From: [REDACTED]
Sent: 22 December 2020 17:07
To: Kathryn Welch
Subject: Re: Request for further information FG/169/20/T

SKETCH 1

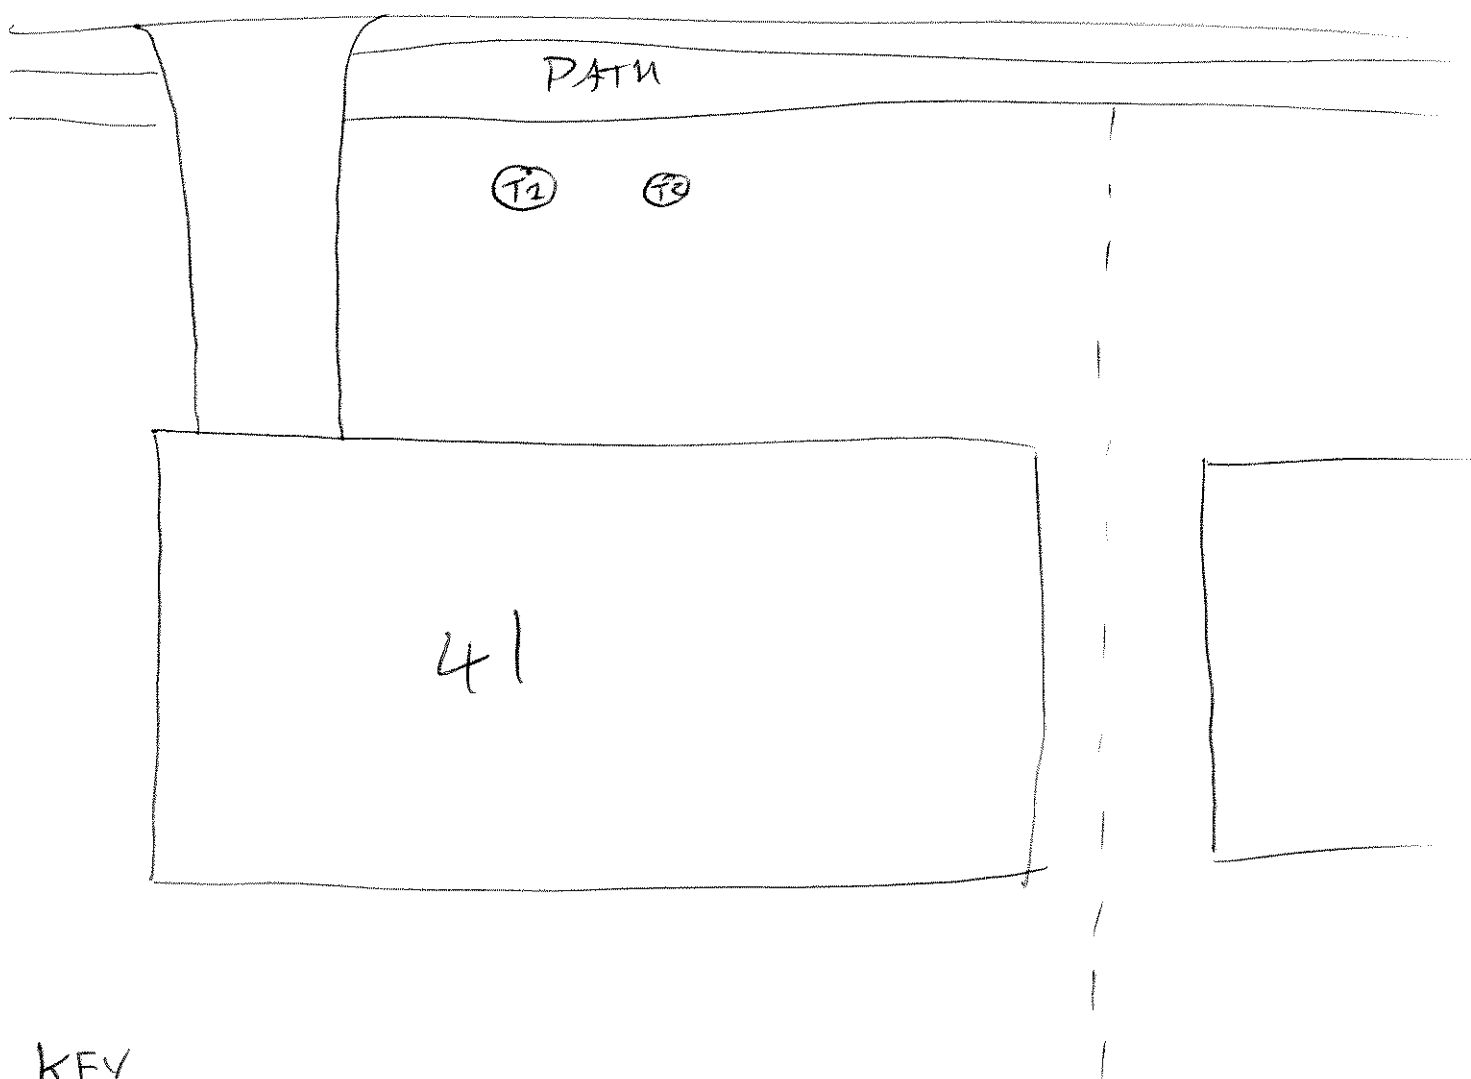
Sorry you are stating **by** 2m still, I need to know what the proposed measurement of the branch will be after pruning, so I need the 'pruned to' measurement. This is to enable us to easily verify if the works have been undertaken as approved, so we can see what remains of the tree.

I have never had to do that measurement before in any TPO applications. The branch will be pruned back to approx. 3m from the trunk.
